Reference: SSD-5119. Proposal for **Crawfords Freightlines Ammonium Nitrate Storage Facility**

27th February 2012

This is a submission objecting to Crawfords Freightlines application for Ammonium Nitrate Storage facility at 158 Maitland Rd Sandgate 2304, a suburb of Newcastle.

Figure 1 Surrounding land uses

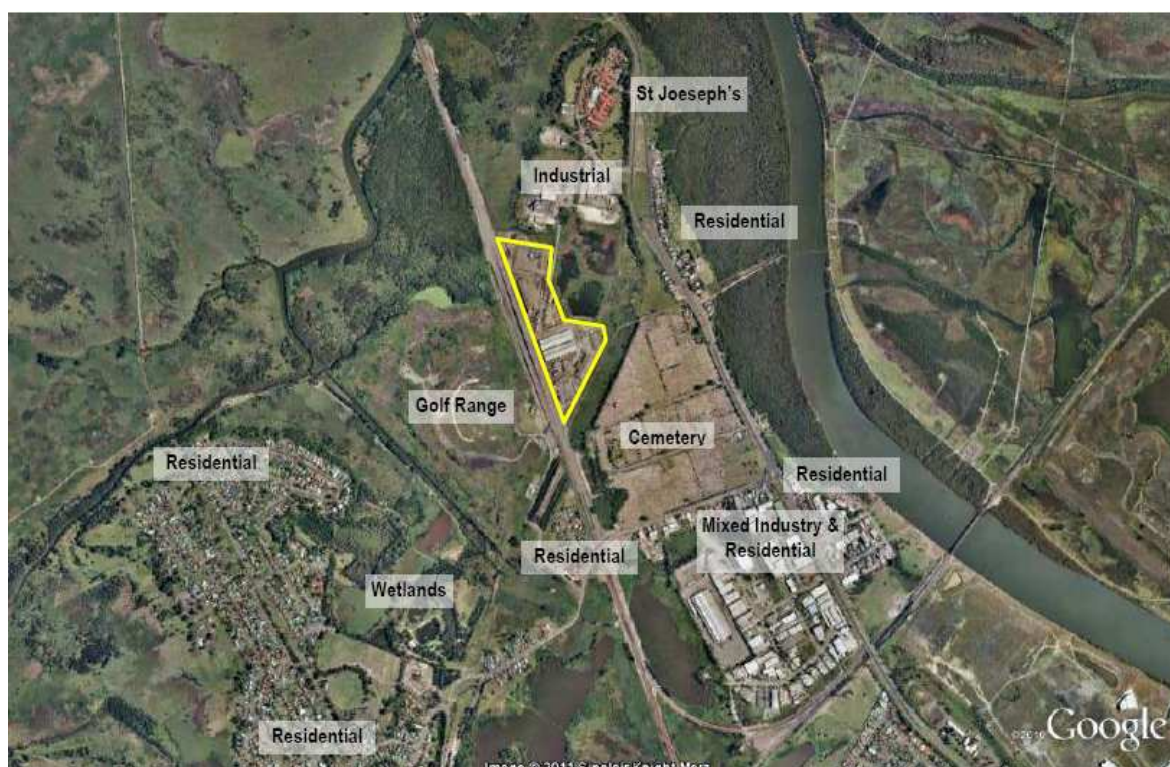
Crawfords have not provided a proper evacuation plan for the residents or visitors of the nearby Nursing Home, the residential areas, the Golf driving range, the highway running past their storage area, or the visitors to the cemetery as shown in their Figure **1.4.3 Surrounding Land Uses**.

It is important to point out that whether accidental, or deliberate tampering with AN is performed, the intensity of any blast could have devastating consequences for the residents or visitors shown in Figure **1.4.3 Surrounding Land Uses** at positions 1, 6, 9, 5 and 7.
